**Our Case Number:** ACP-323849-25

**Re:** The proposed development is for a mixed use development that seeks the regeneration and adaptive reuse of a strategic brownfield site, as part of the Limerick City and County Council 'World Class Waterfront revitalisation and transformation project' 'Cleaves Riverside Quarter' in the townland of Farranshone More in Limerick City.

Ref: ACP-323849-25

I am writing to request you seriously review the Masterplan being submitted for the Cleaves Riverside Quarter in Limerick city and to request the Architects submit revised plans with solutions. With such a large investment, it is crucial to take the necessary steps to ensure the city's heritage and aesthetic is maintained and not destroyed. Limerick City has a beautiful Georgian centre (sadly neglected) plus medieval quarters and a rich mix of architectural styles mostly built on a pleasing human scale, which is why we love our city.

STUDENT HOUSING / QUARRY WALL BAT HOUSE ELEVATION- 1:50 @ A1

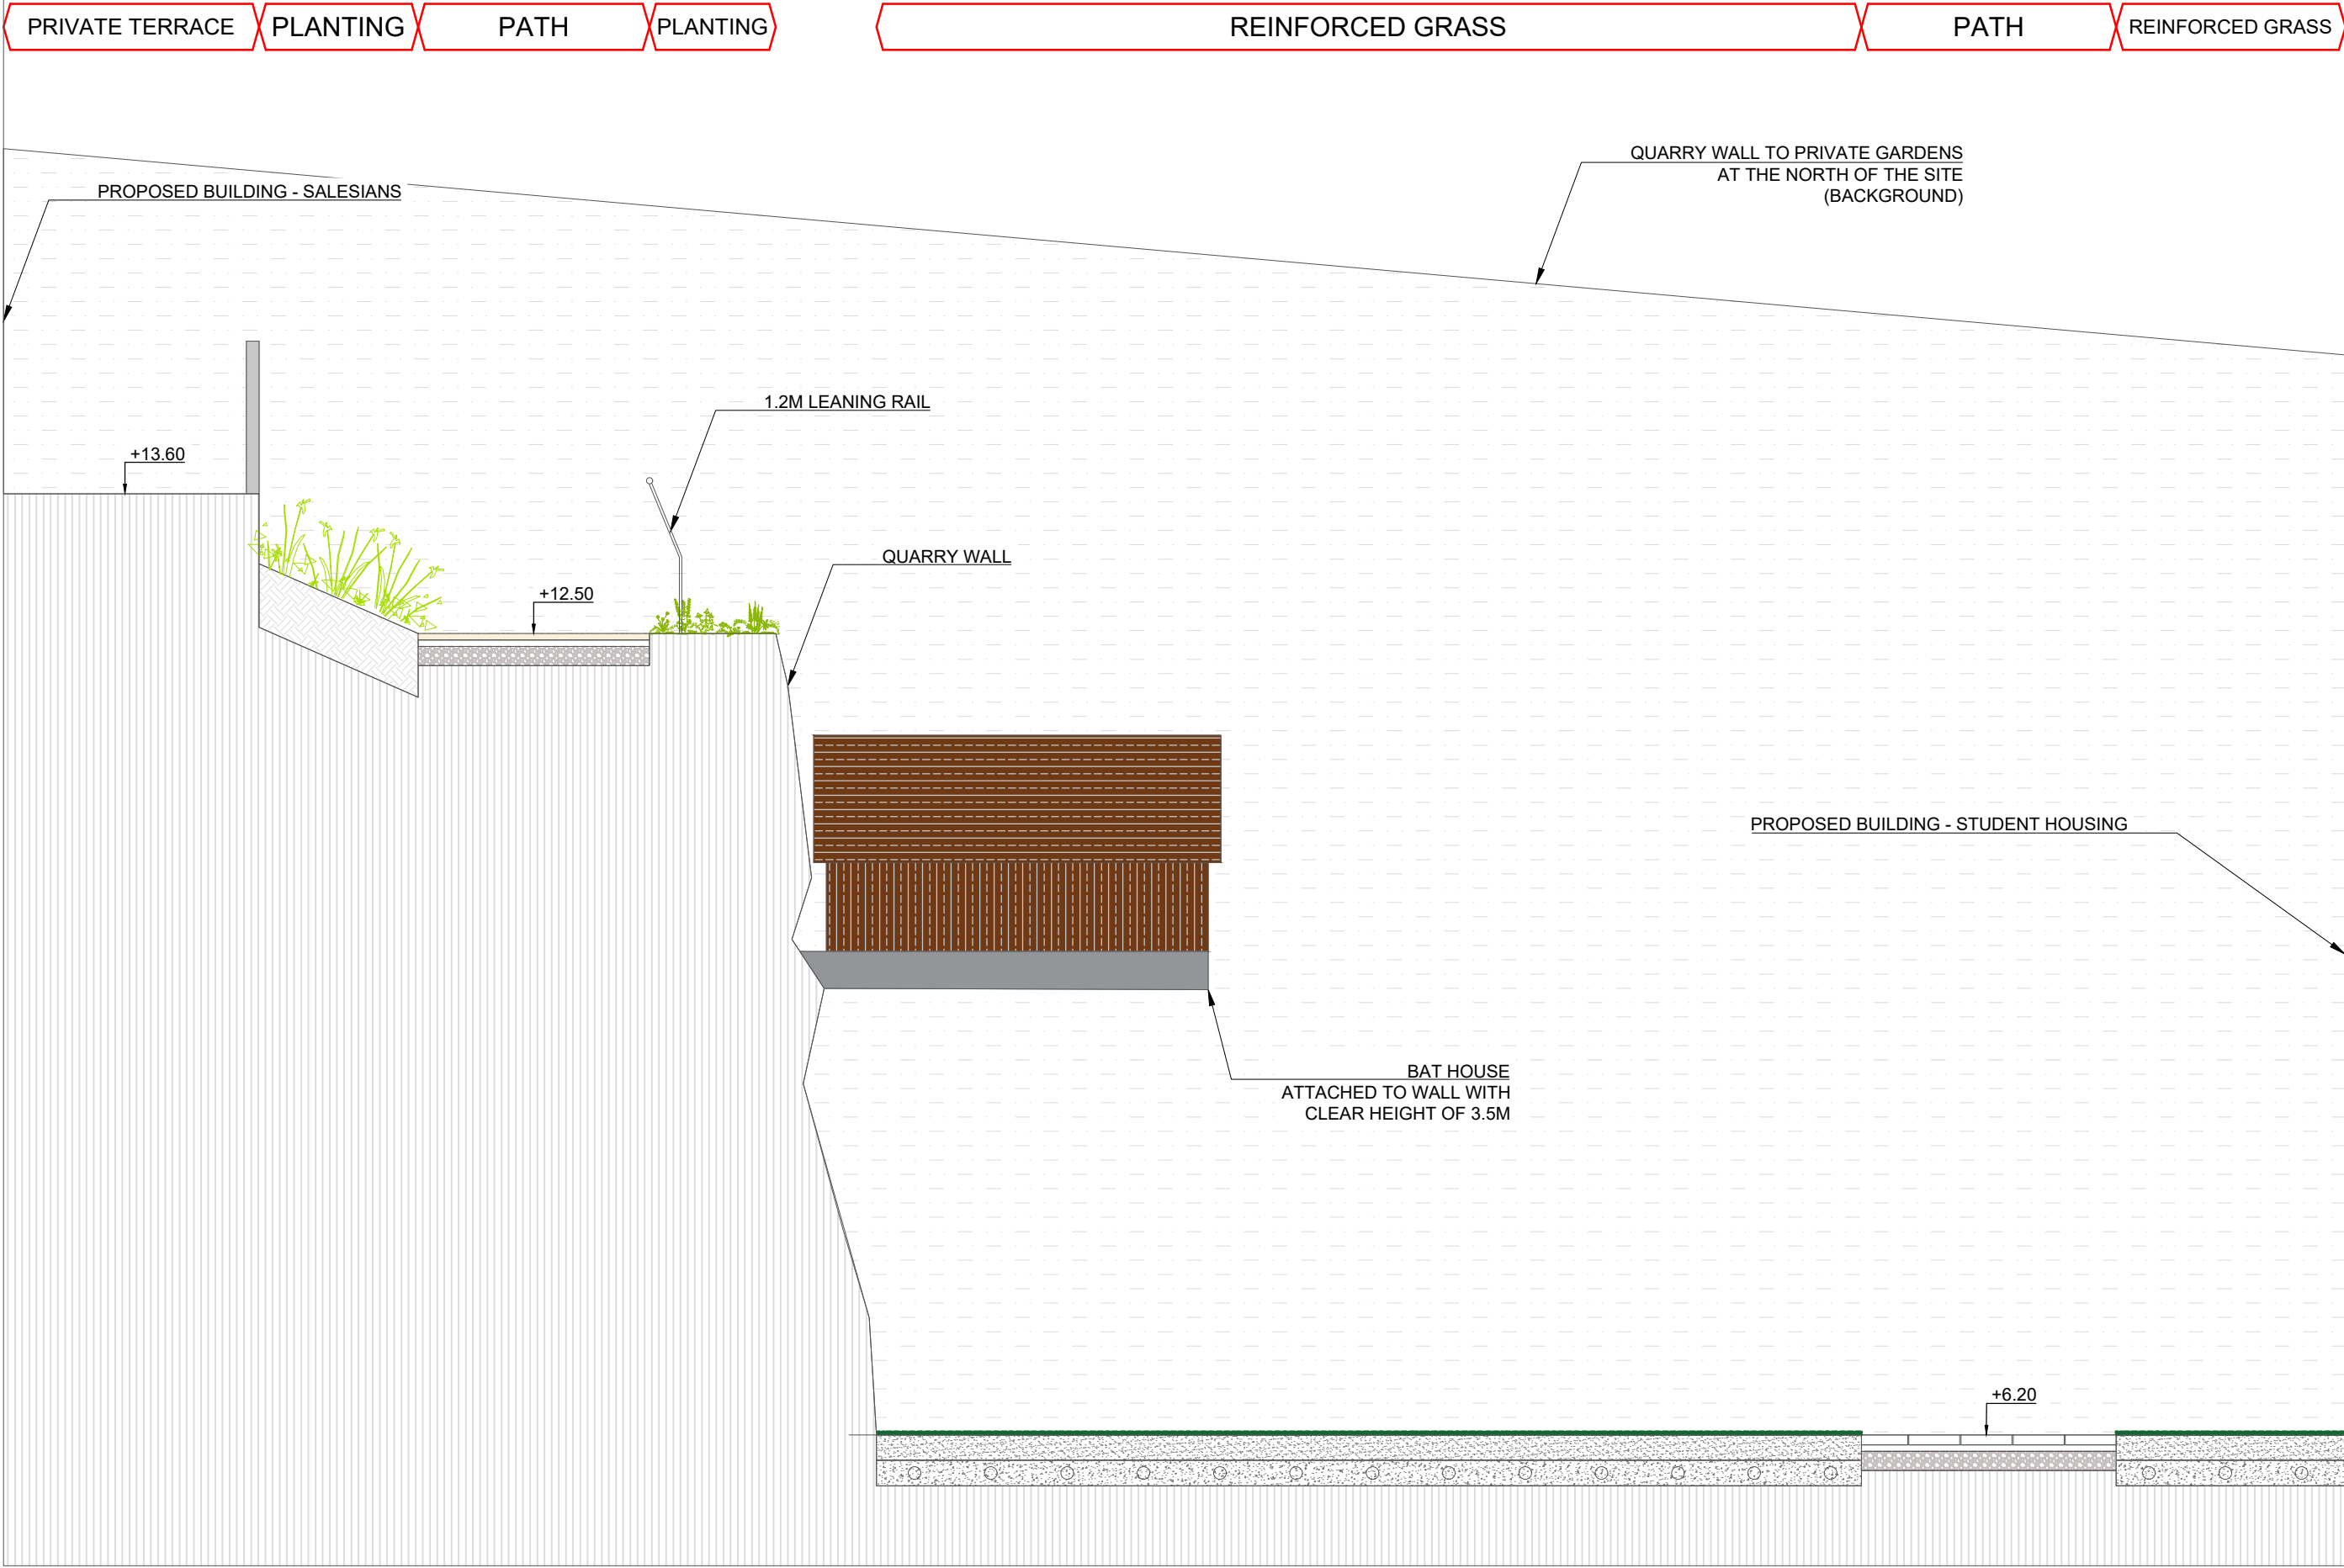
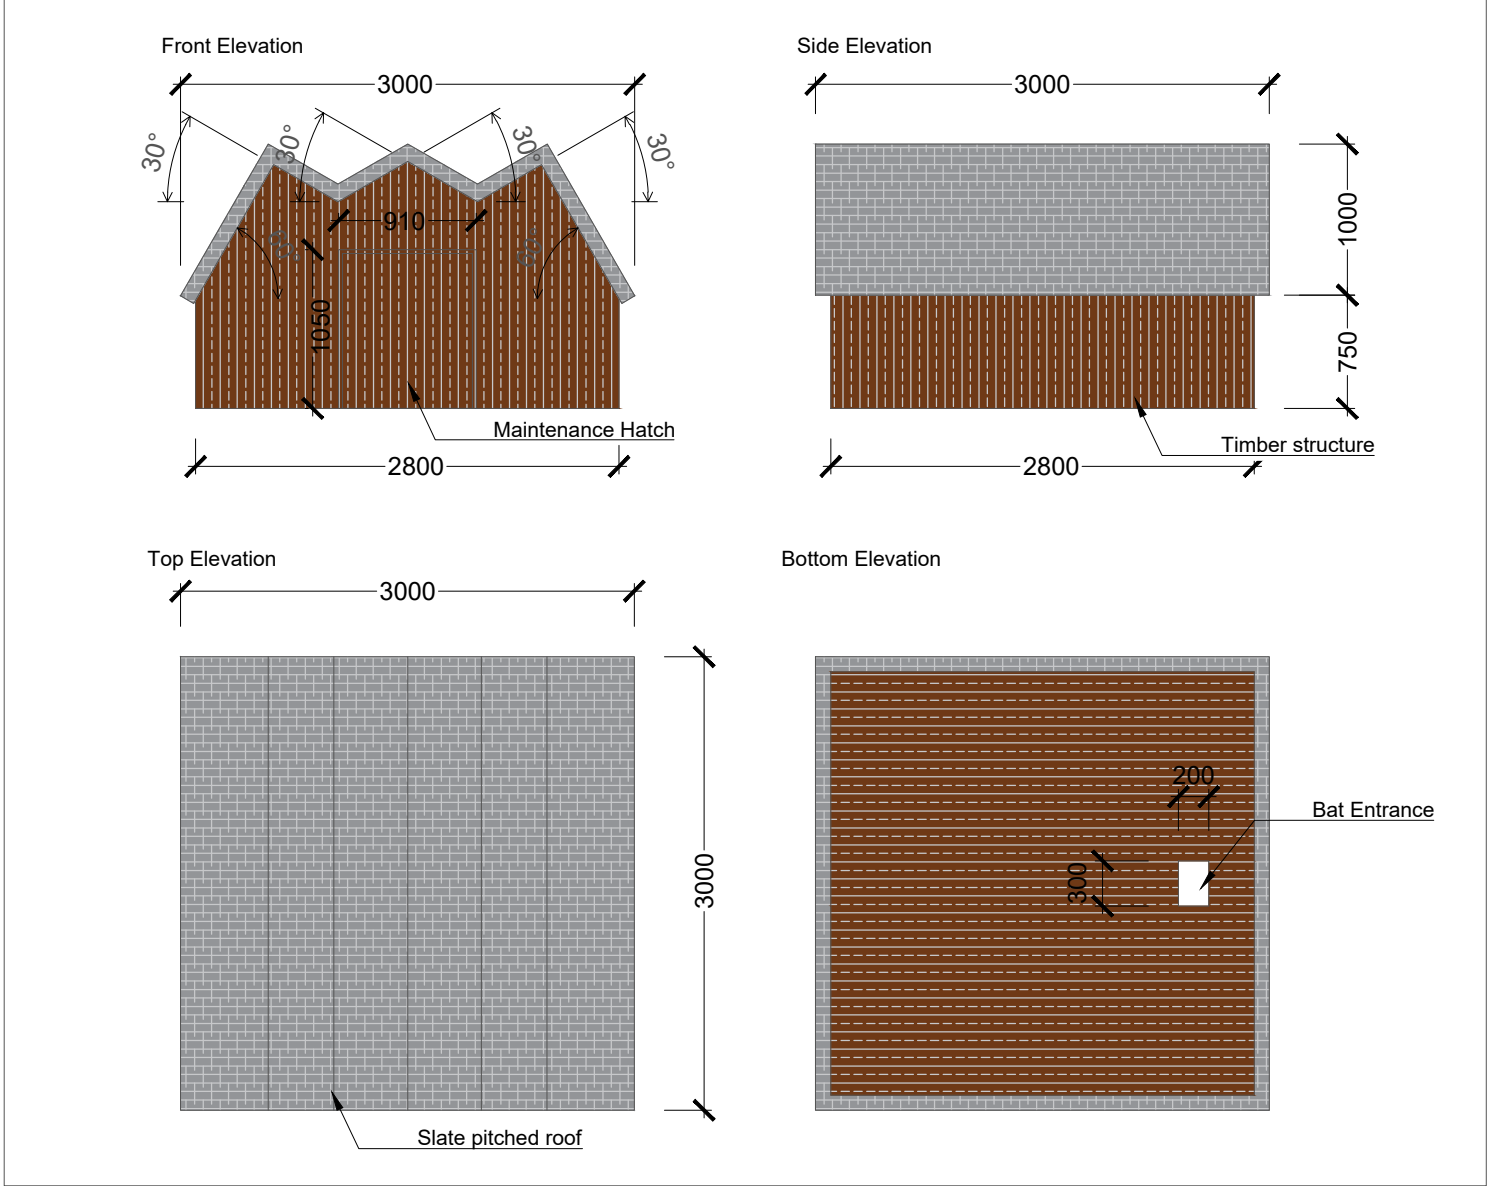
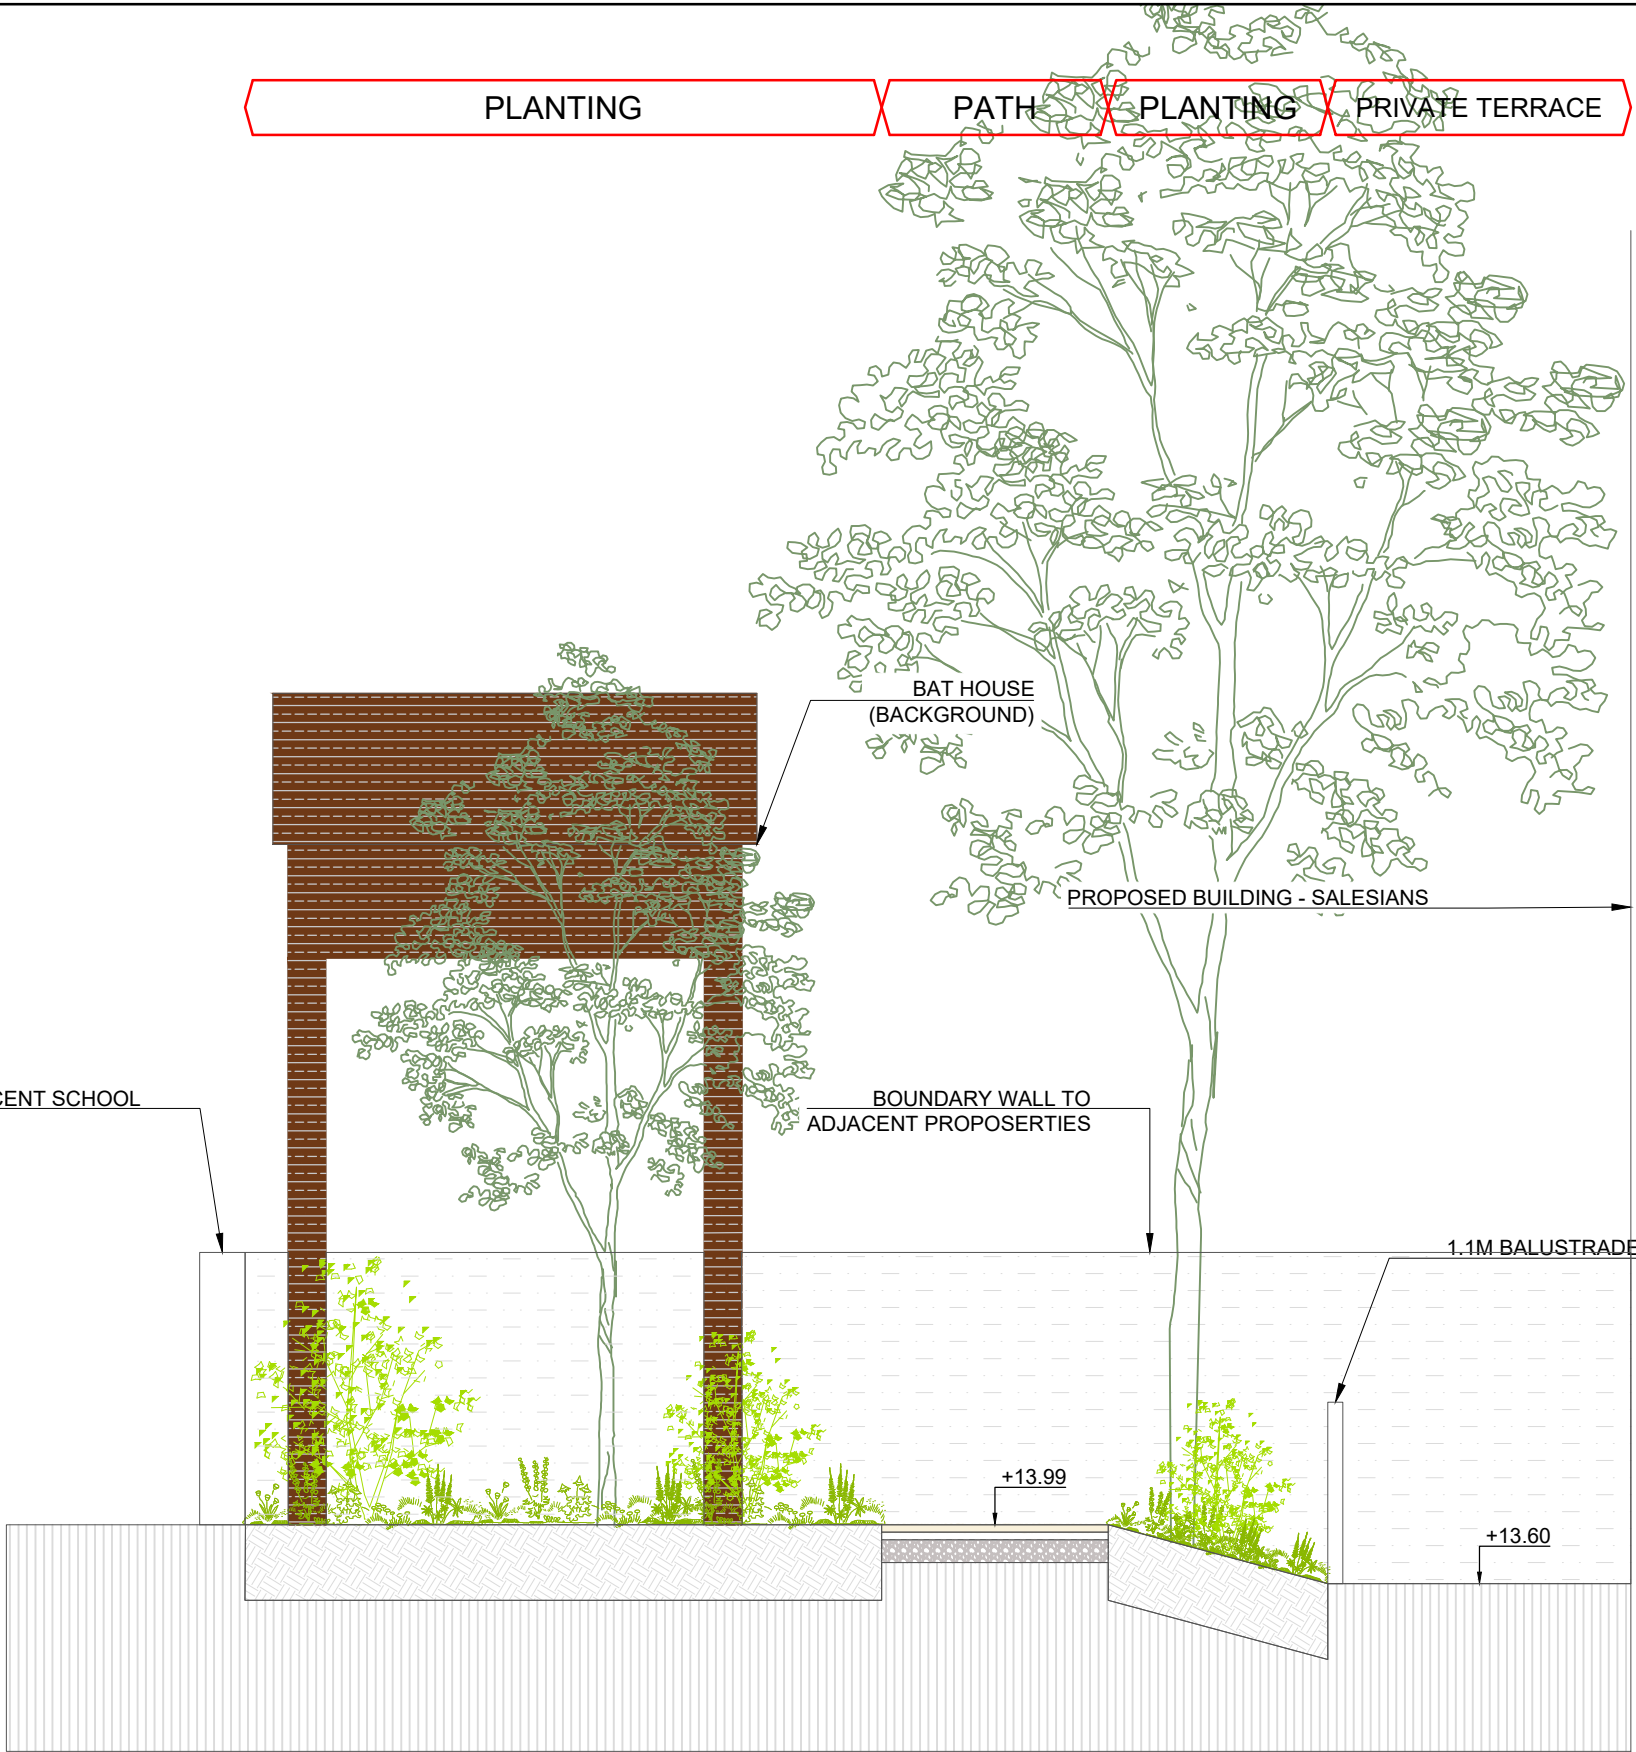
6 – Why is there a plan to build a Bat House? If there are bats on site which are protected, can these be moved to a country location? Will this Bat House not be a health hazard for the residents of the 500 homes onsite?
